Building C, Walker Street, Rhodes

MP 10_0105 MOD 5

Modification to rooftop to provide a private garden

Secretary's
Environmental Assessment Report
Section 75W of the
Environmental Planning and Assessment Act 1979

Drawing Name:
Level 20 Plan

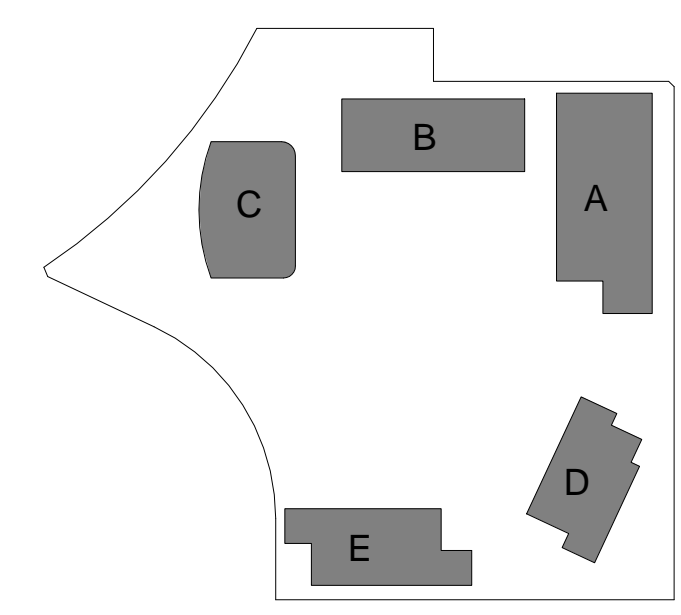
The proposal seeks to modify the rooftop of Building C through providing a private rooftop garden. In particular, the proposal includes:

- the construction of a timber deck with a pergola on the western side of the roof;
- replacement of the concrete and gravel finish on the roof with astro turf;
- planting in designated areas; and
- reconfiguration and extension of the plant and lift overrun to include a stairwell (where the unit owners will gain access to the rooftop), toilet and maintenance store.

Noting the above, the department considers that the proposal does not impact on the approved bulk and scale of the building and therefore the proposed modifications are supported.

Drawing Name  
**Elevations - BLDG C**  
**North & South**

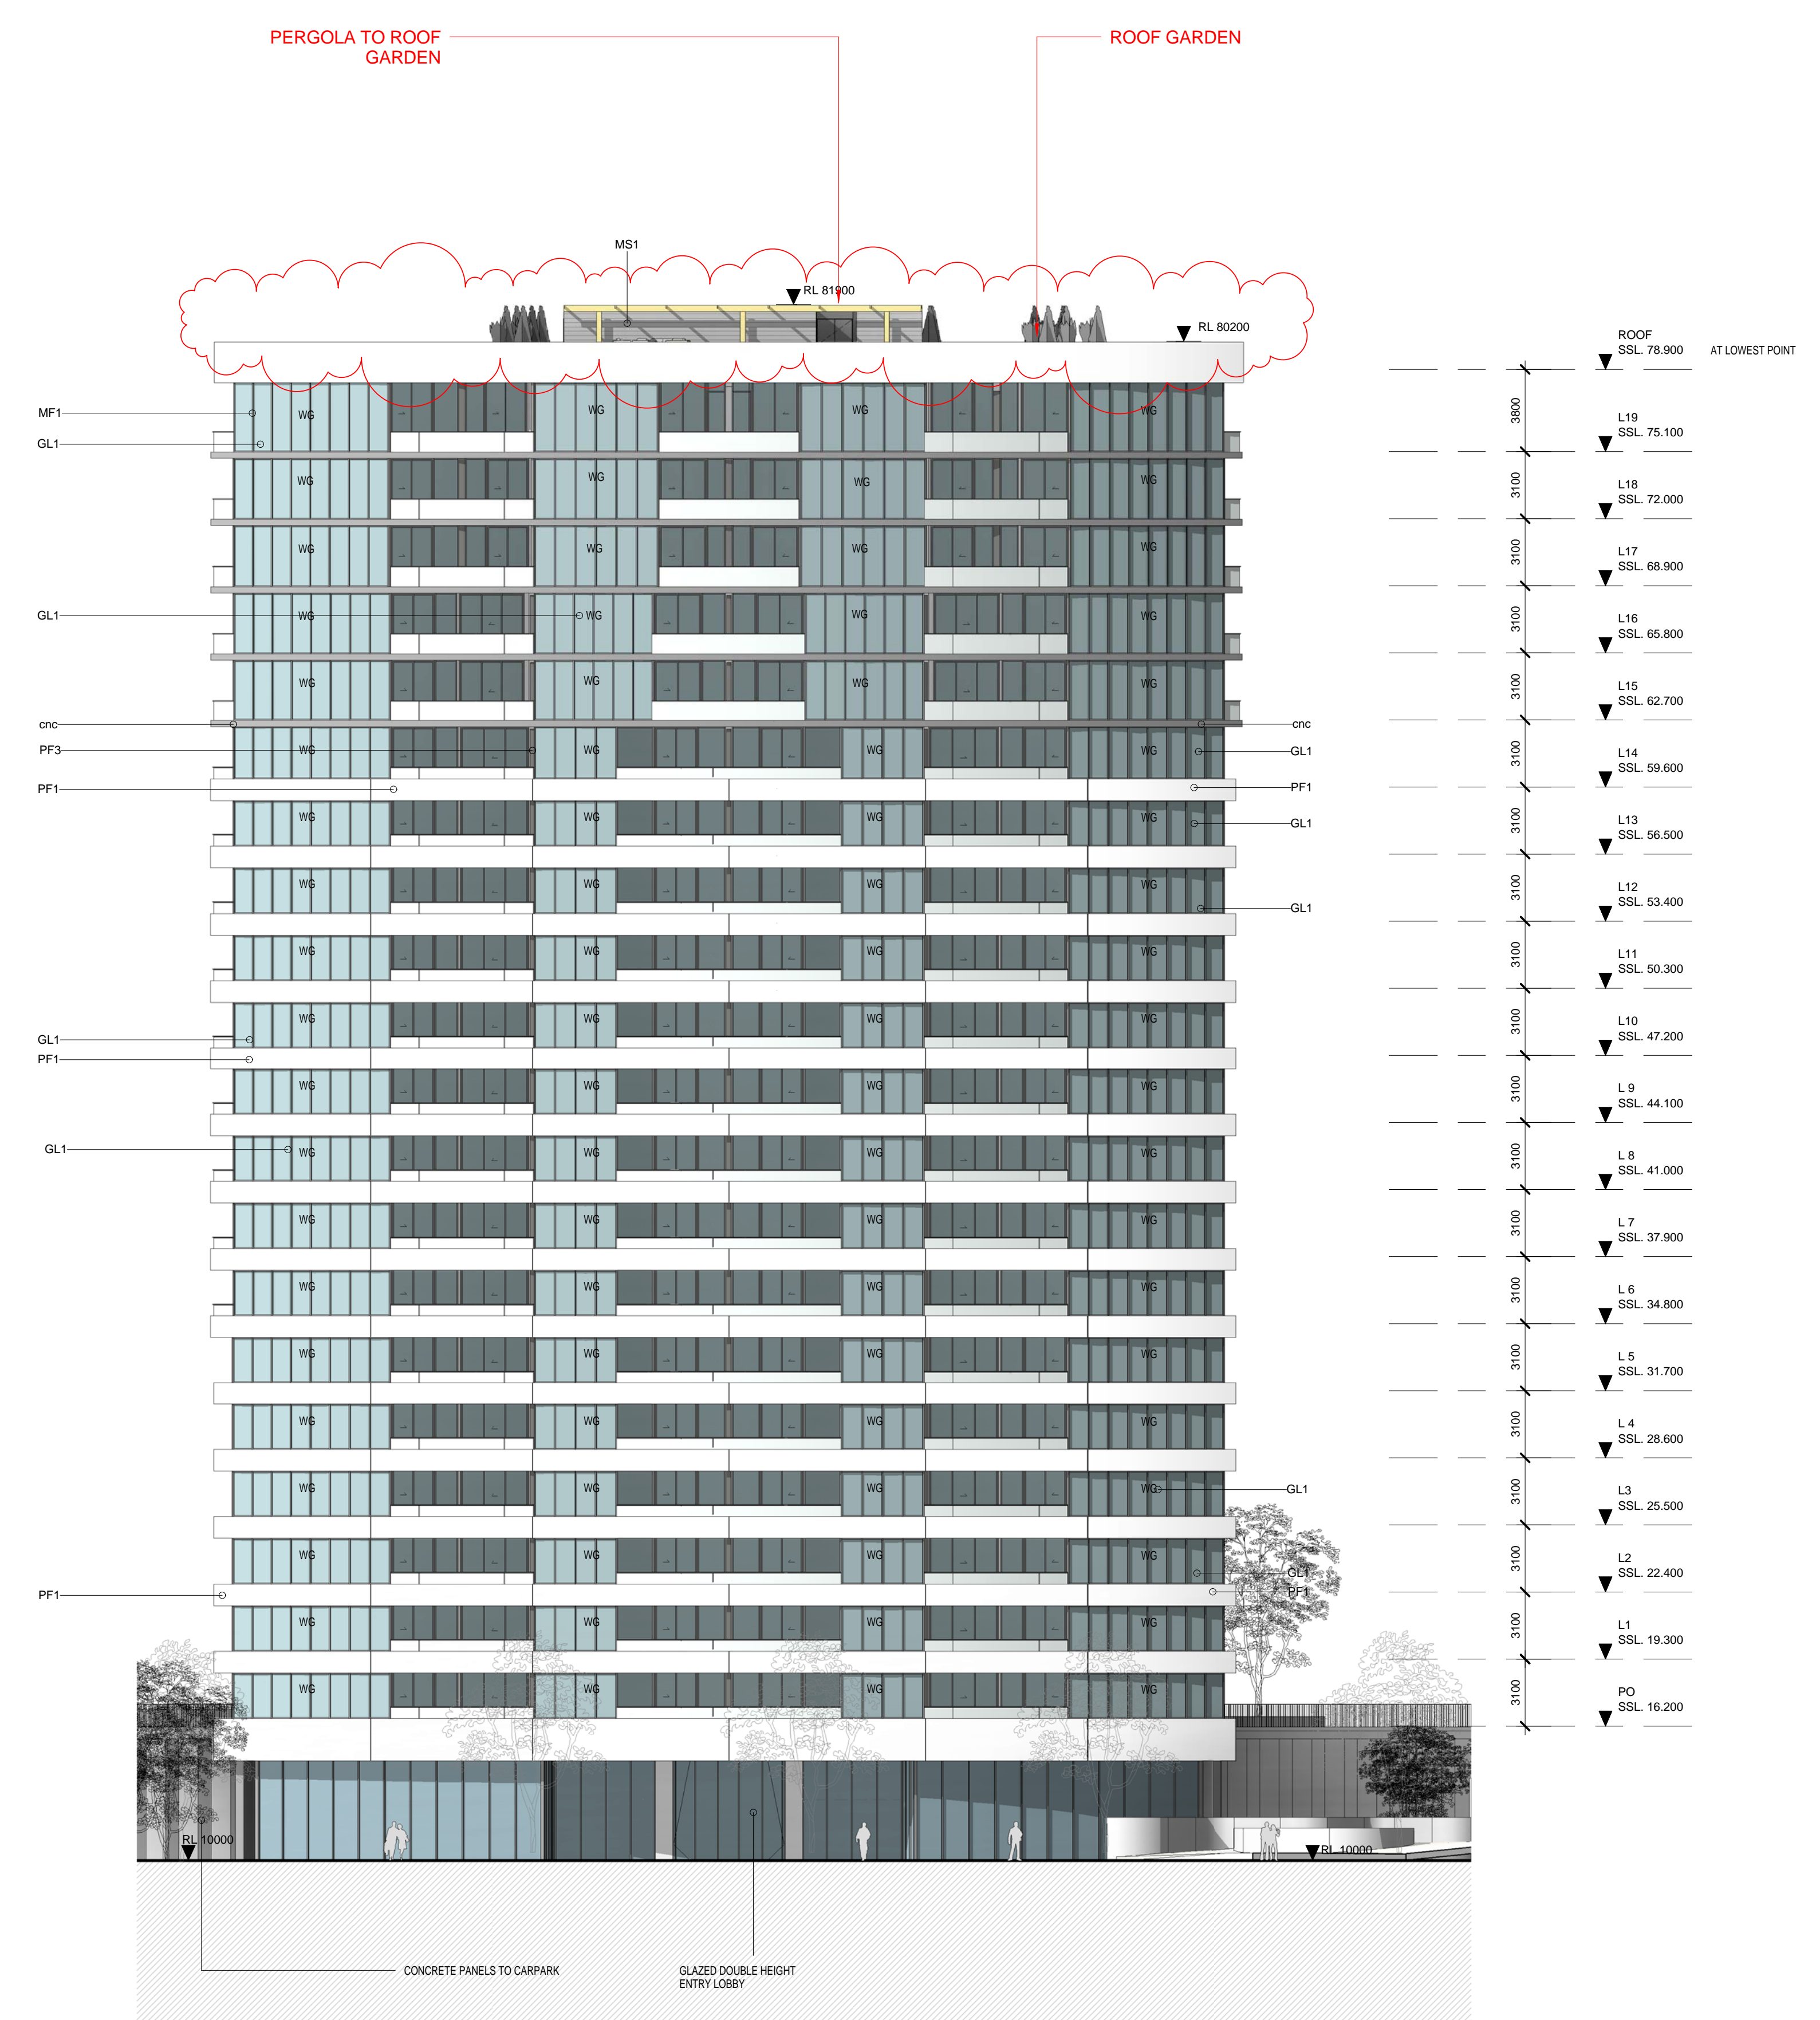
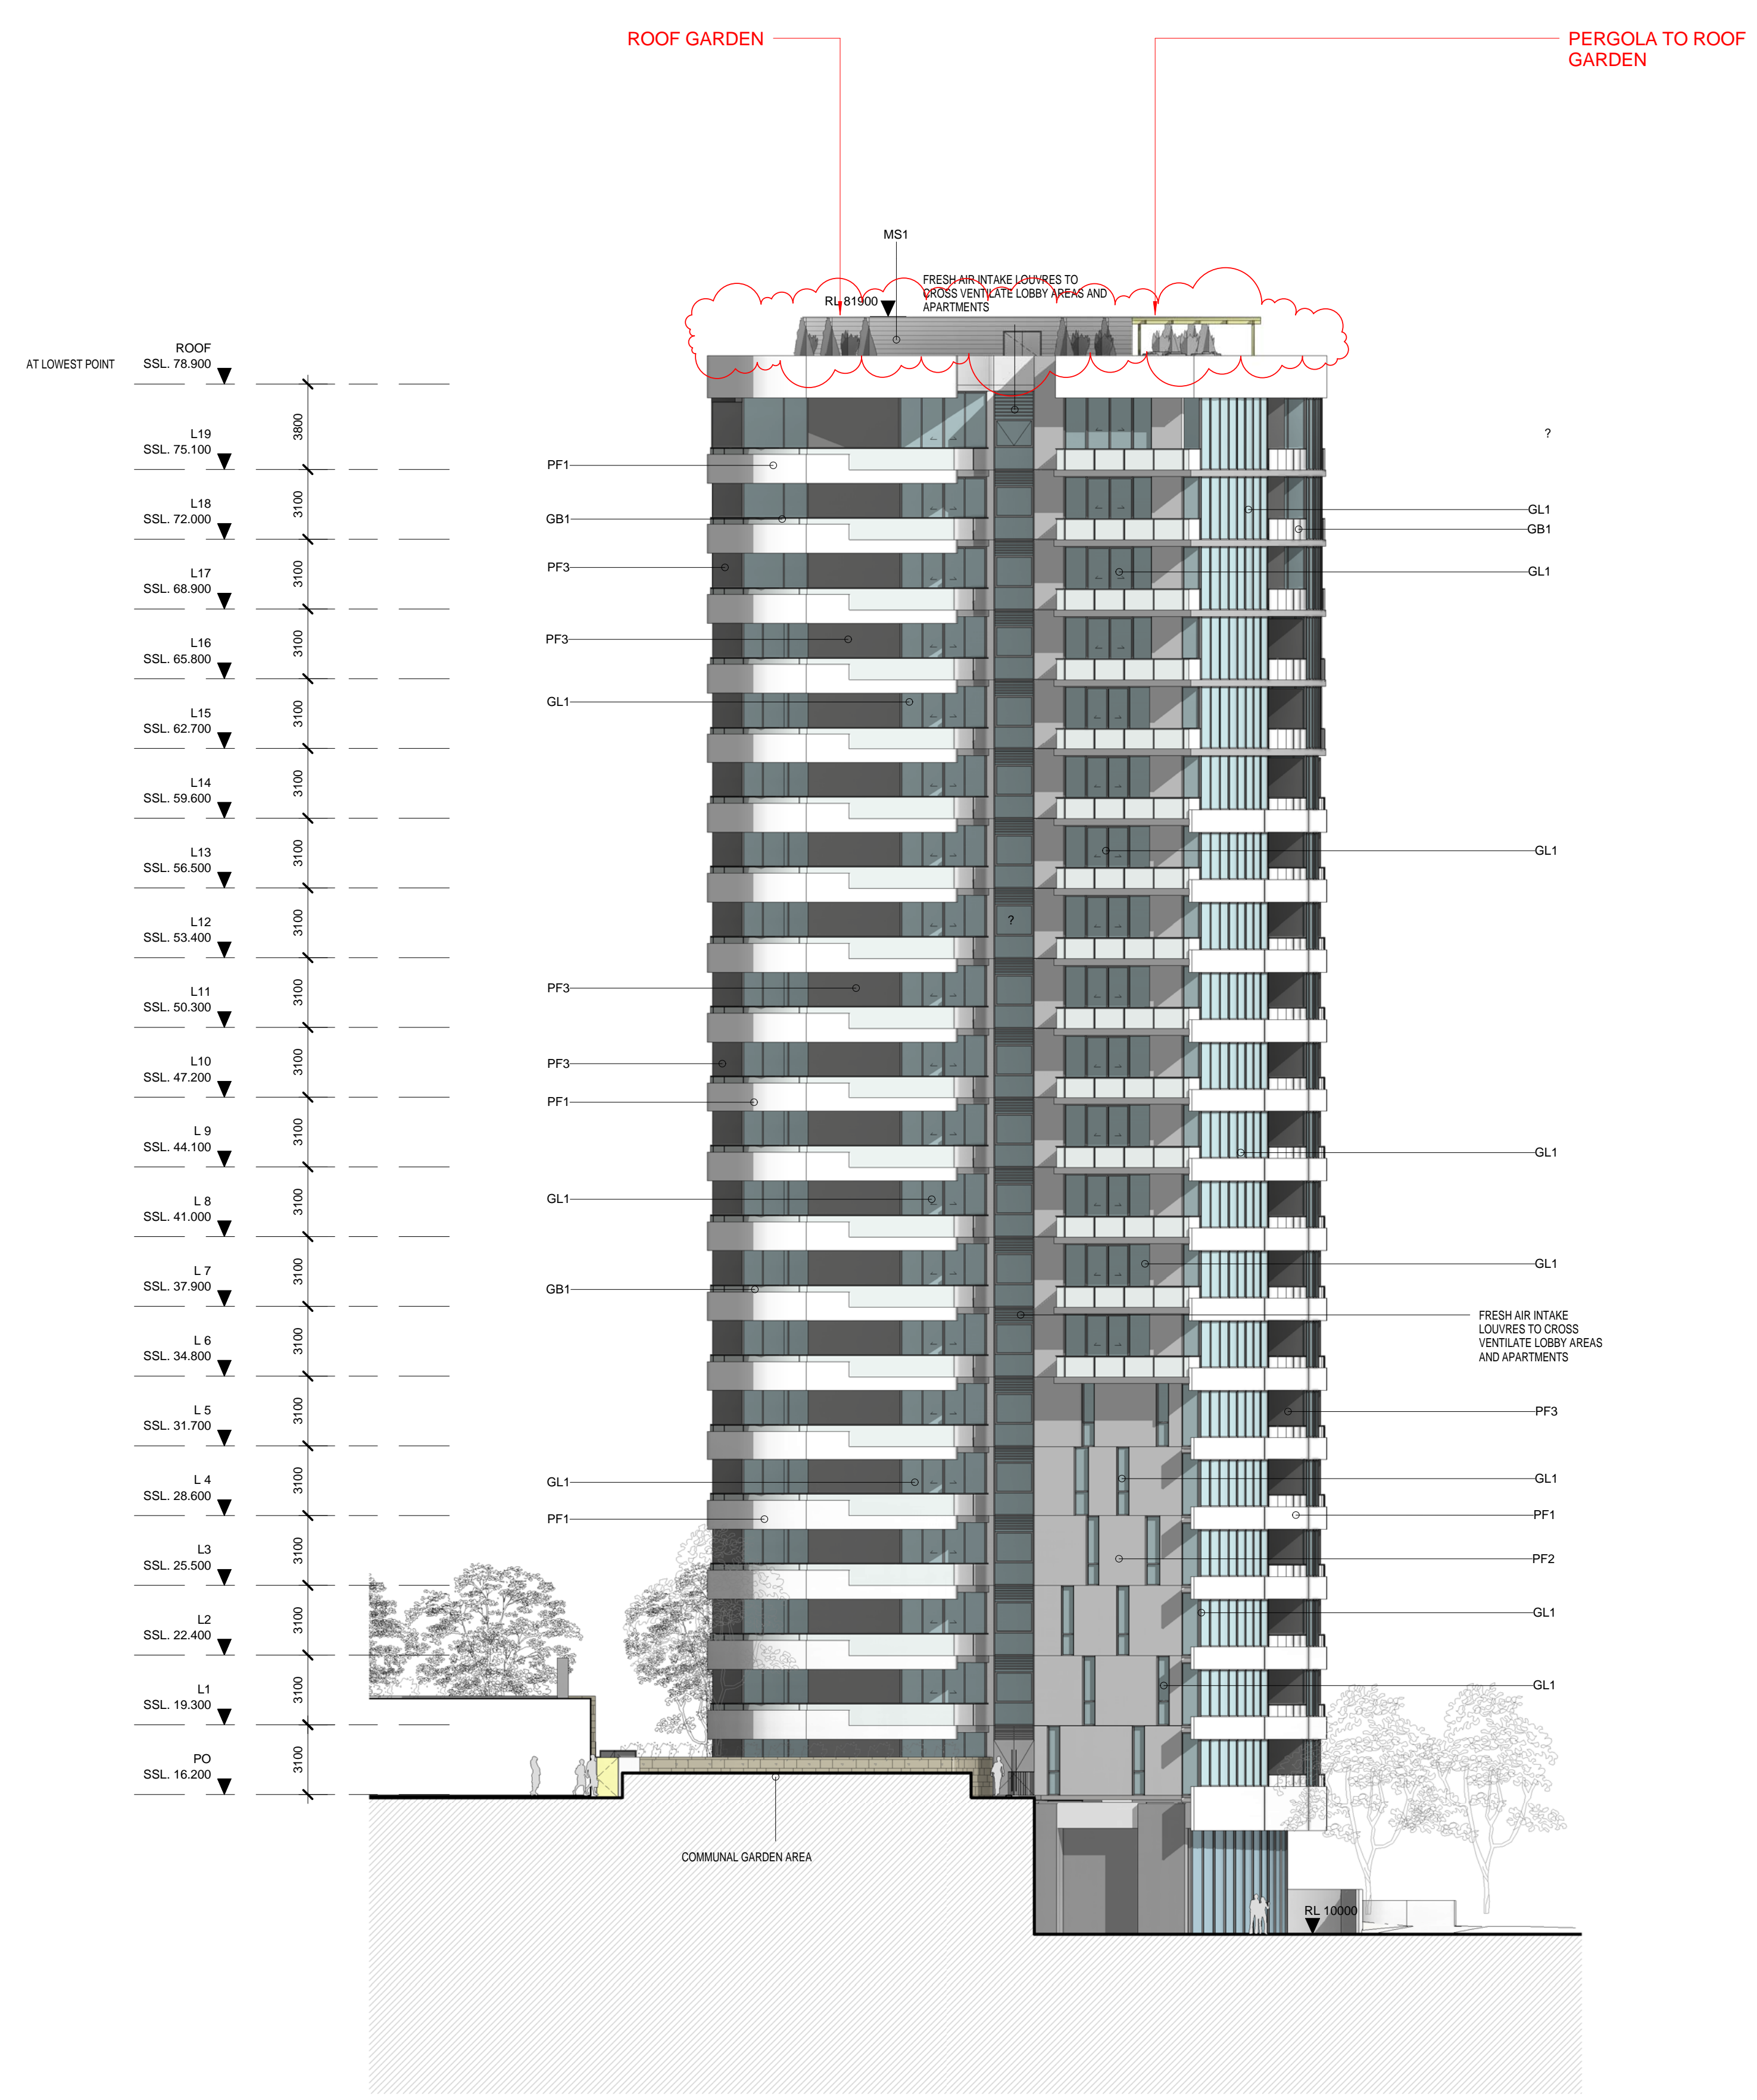
As a consequence of the above amendments, the exterior appearance of the approved rooftop plant area is modified (**Figure 4**). The overall height of the building and plant is maintained, however the modifications to the plant and lift overrun, new pergola and landscaping, will alter the visual appearance of the rooftop of the building when viewed from neighbouring buildings.

Notwithstanding, the department considers that the overall visual impact will be improved. The introduction of landscaping and a pergola will assist in screening and minimising the visual dominance of the roof top plant and lift overrun.

As the overall height is unchanged and the plant/lift overrun and pergola is setback from the building edge, the proposal will not result in any additional overshadowing impacts.
